| Application Ref: | 2025/0862 | | |  Ribble Valley Borough Council <small>www.ribblevalley.gov.uk</small> |
| DELEGATED ITEM FILE REPORT: | | | | APPROVAL |

| Development Description: | Proposed change to the sign, acrylic lettering to replace the existing and to be snap-fixed mounted onto the fascia. Existing awnings/canopies to be removed. |
| Site Address/Location: | 7 York Street Clitheroe BB7 2DH |

Drawing Title
EXISTING AND PROPOSED FLOOR PLAN AND FRONT ELEVATION.

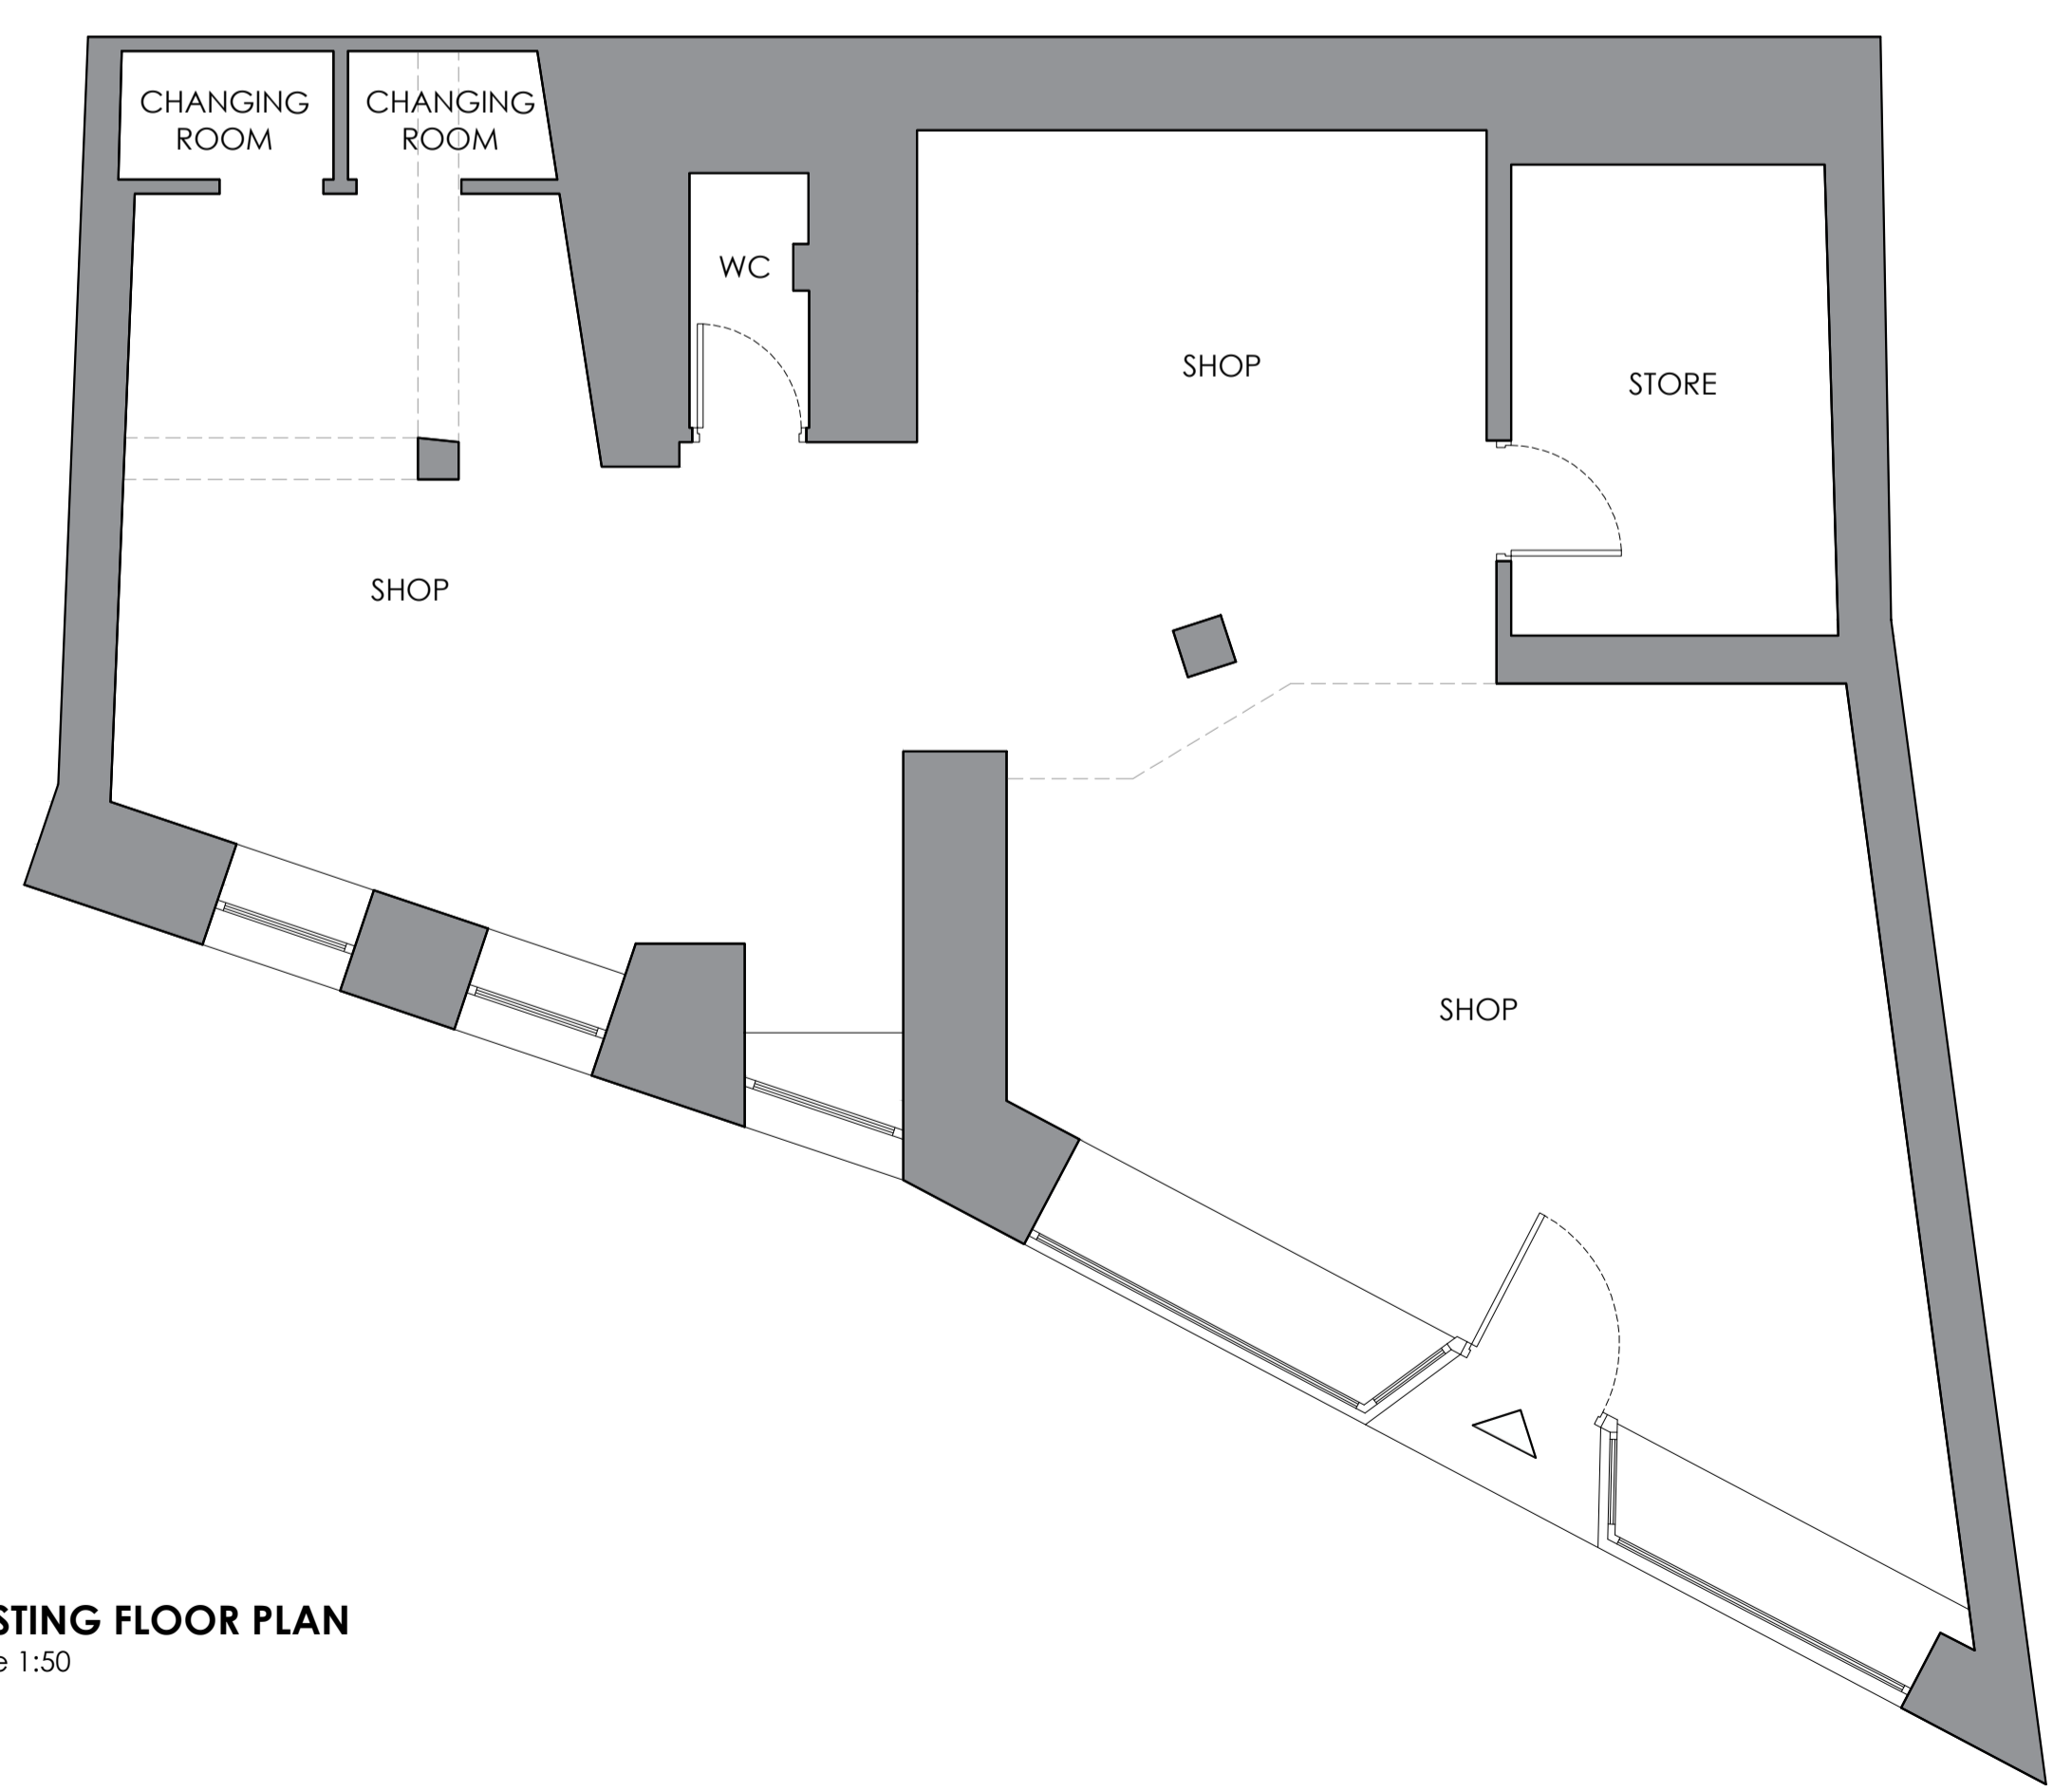
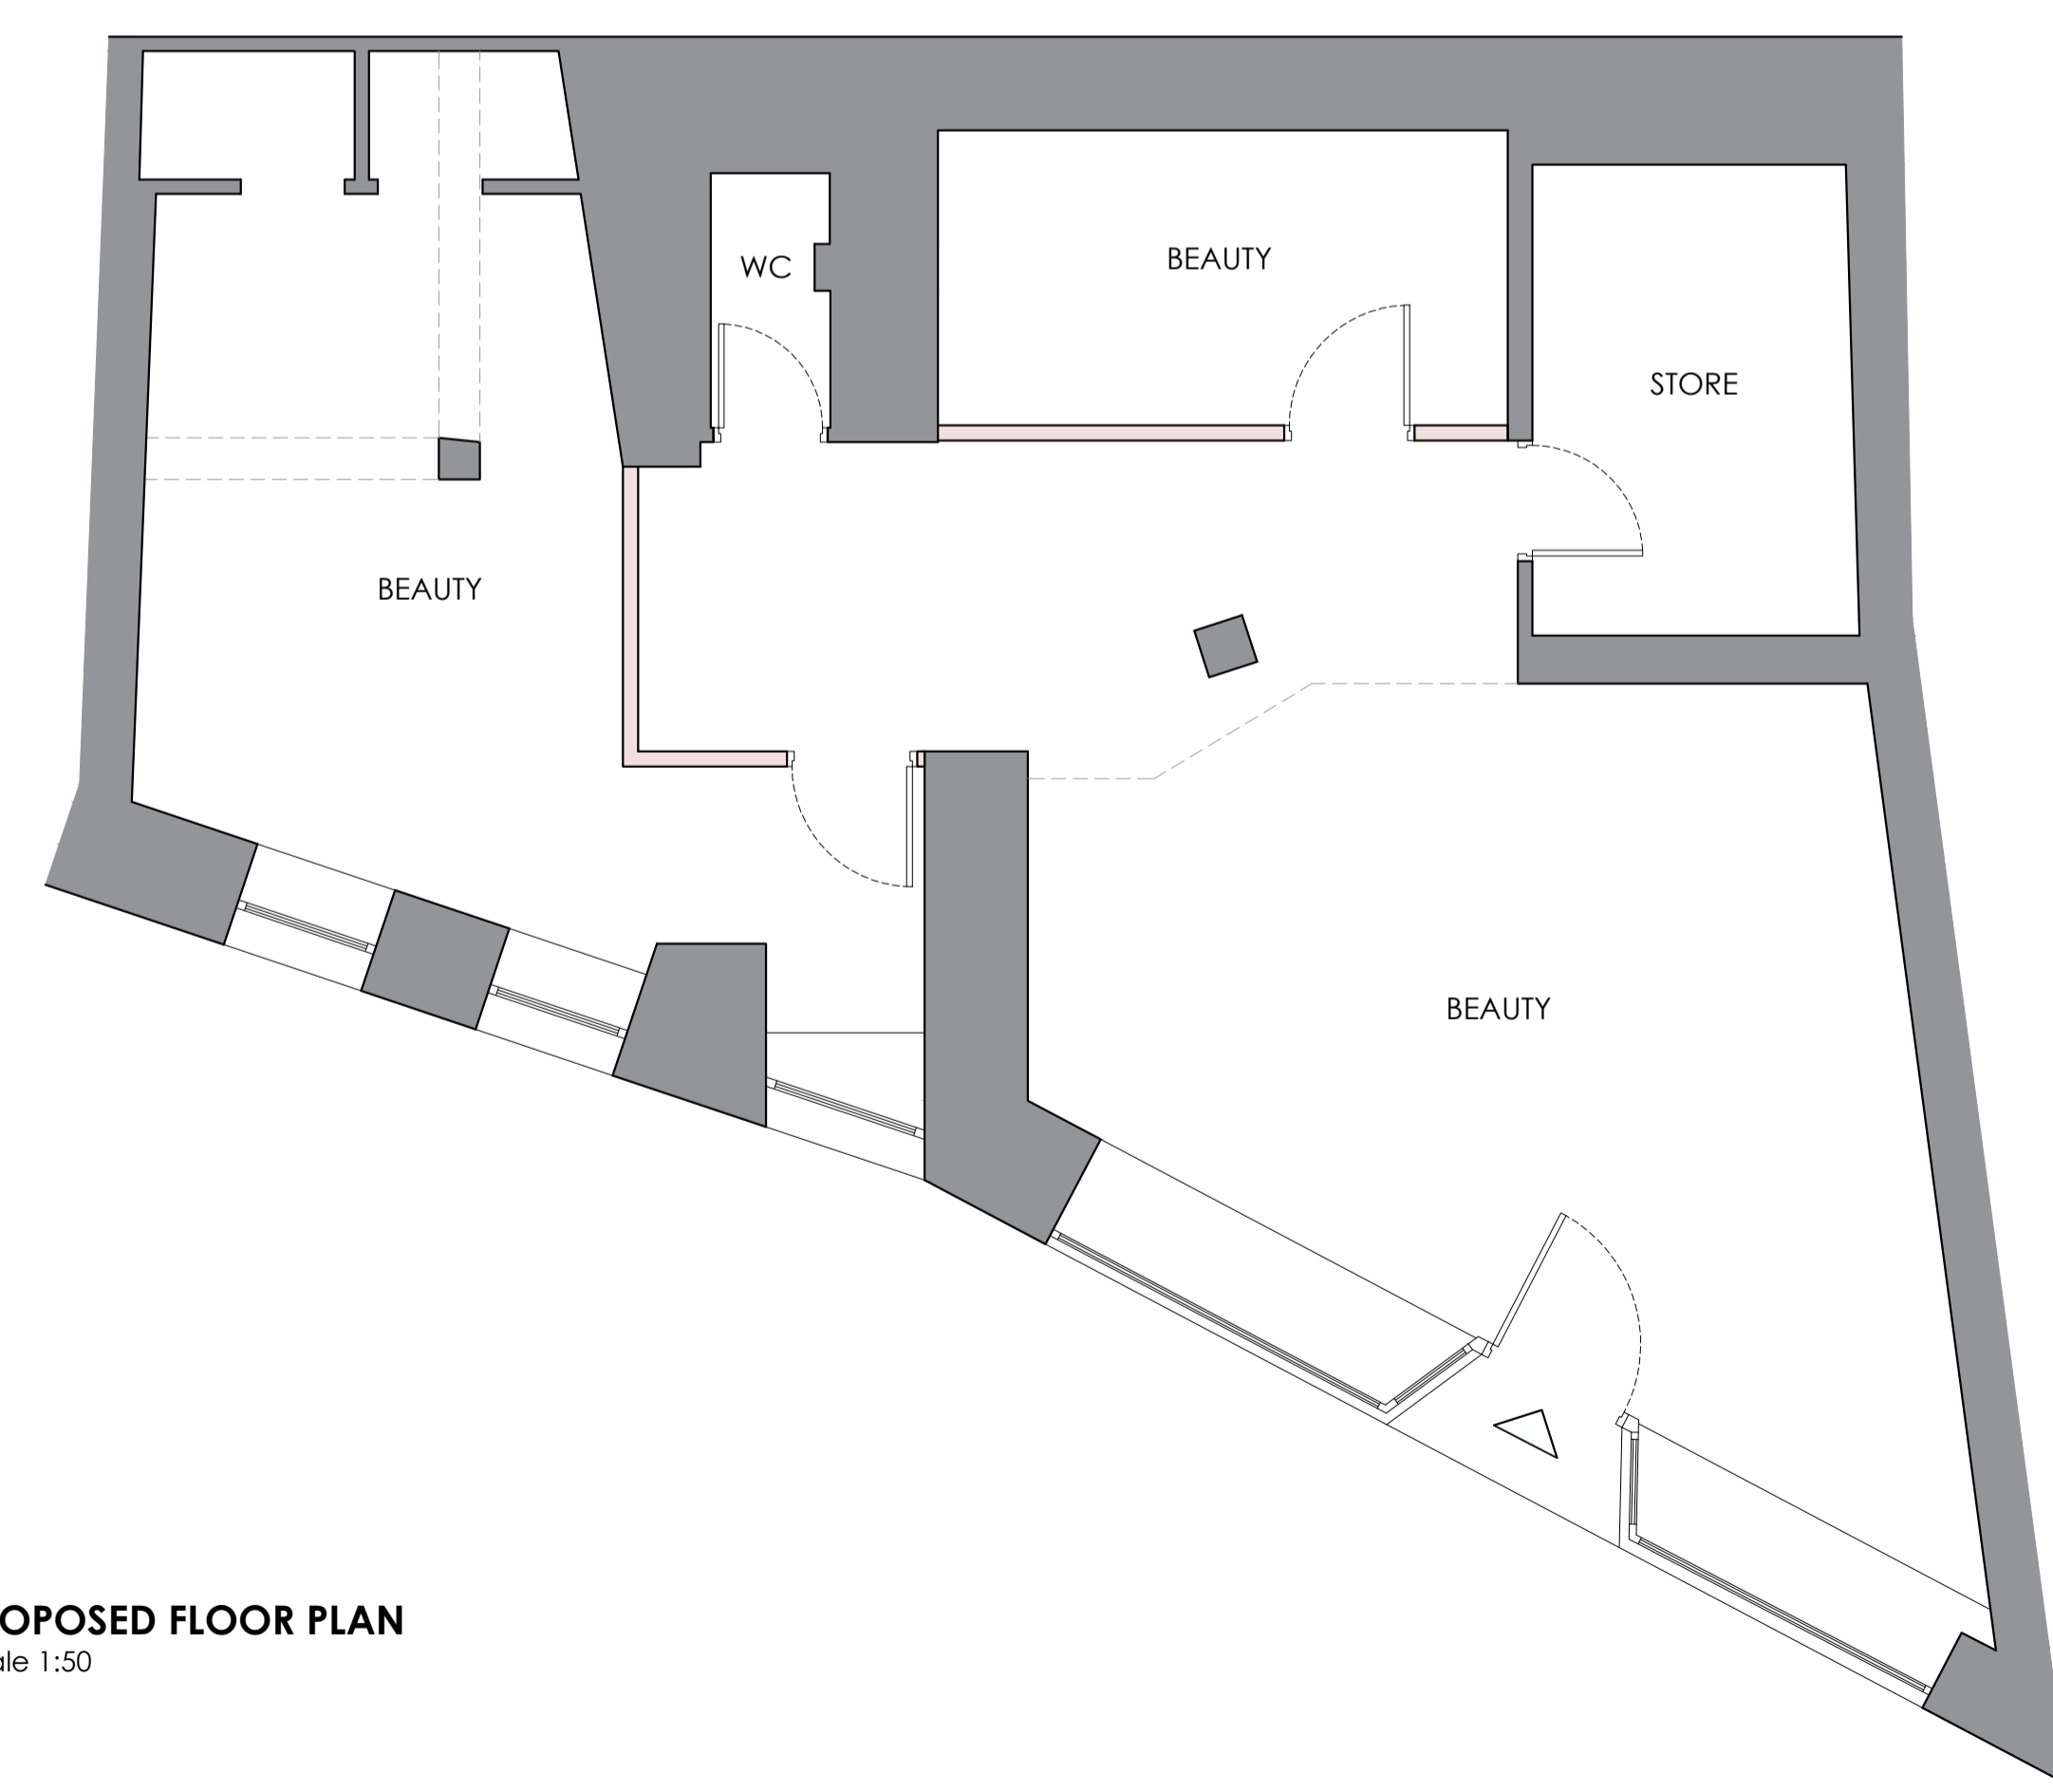
The application seeks advertisement consent for the installation of a replacement fascia letter signage upon the fascia margin of the property. It is proposed that the letter signage will occupy a central location within the fascia margin, consisting of individual acrylic lettering.

The fascia signage will be of a modest appearance similar to the scale and configuration of other such signage within the immediate area, with the lettering considered to be well-proportioned in relation to the existing fascia margin.

In this respect it is not considered that the proposed fascia signage will be read as being either visually incongruous nor anomalous within the immediate and wider streetscene. In this respect the proposed replacement hanging signage is unlikely to result in any measurable harm to the setting or inherent character of nearby Designated Heritage Assets.

The fascia signage will be of a modest appearance similar to the scale and configuration of other such signage within the immediate area, with the lettering considered to be well-proportioned in relation to the existing fascia margin. In this respect it is not considered that the proposed fascia signage will be read as being either visually incongruous nor anomalous within the immediate and wider streetscene. In this respect the proposed replacement hanging signage is unlikely to result in any additional material impacts upon the character or visual amenities of the designated Clitheroe Conservation Area or the wider streetscene.

The letter signage will replace existing signage, being in a similar location albeit with the lettering, in its entirety, being larger than that of the existing configuration. It is not proposed that the signage will benefit from internal or external illumination as such the proposed signage is unlikely to result in any adverse impacts upon nearby residential amenities.

That advertisement consent be granted subject to the imposition of conditions.
